Online Comment

Application H22-1249-21
Location Land North West of High Road Weston Spalding
Proposal Residential development for the erection of 150 dwellings and associated open space and infrastructure - re-submission of H22-1135-20

Name Sue Armour
Address Environmental Protection Officer SHDC

Date Submitted 19-01-22
For/Against Comments

Client: Persimmon Homes East Midlands	Project: High Road, Weston	Drawing Title: CS2 Gas Precaution Details	Project Engineer: LH	Checked: LH	Status: PRELIMINARY	Size: A3
			Drawn: RM	Approved: LH	Drawing No: E21136/100	Rev: P2
			Date: MAY 21	Scale: AS SHOWN

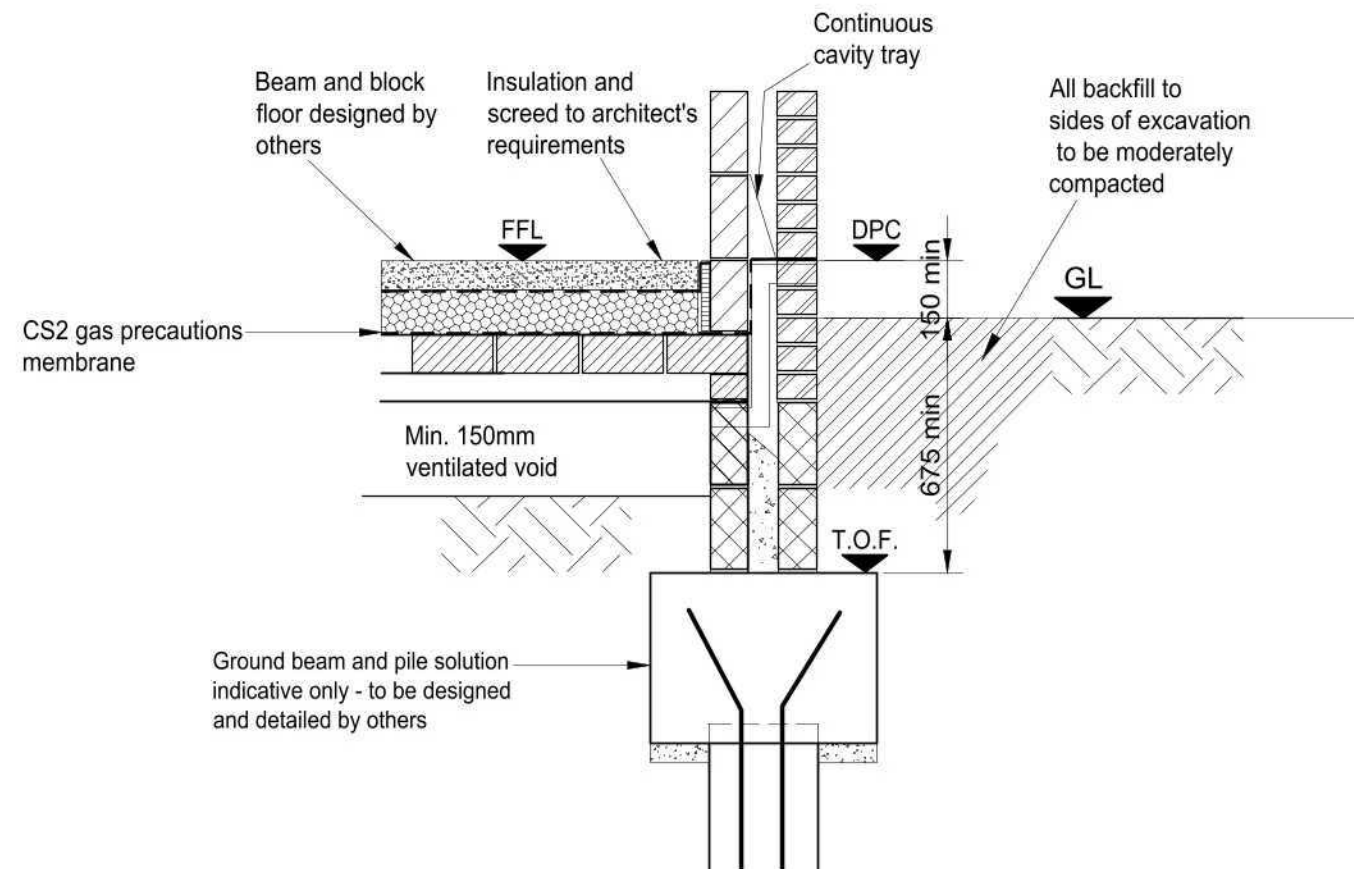
It is proposed to install ground gas protection measures to CS2 as per BS8485:2015 and this is acceptable. Basic detail on the proposed gas protection measures has been supplied, however the proposed scope of validation needs to be agreed in advance as part of the remedial strategy. Guidance on validation of ground gas protection measures can be found in the British Standard, as well as in the YALPAG Guidance 'Technical Guidance on the Verification of Gas Protection Systems' which can be downloaded from

A remediation method statement comprising details of ground gas protection measures to be installed shall be submitted to and approved in writing by the Local Planning Authority.

This shall include details of the proposed verification plan including compliance criteria and monitoring details.
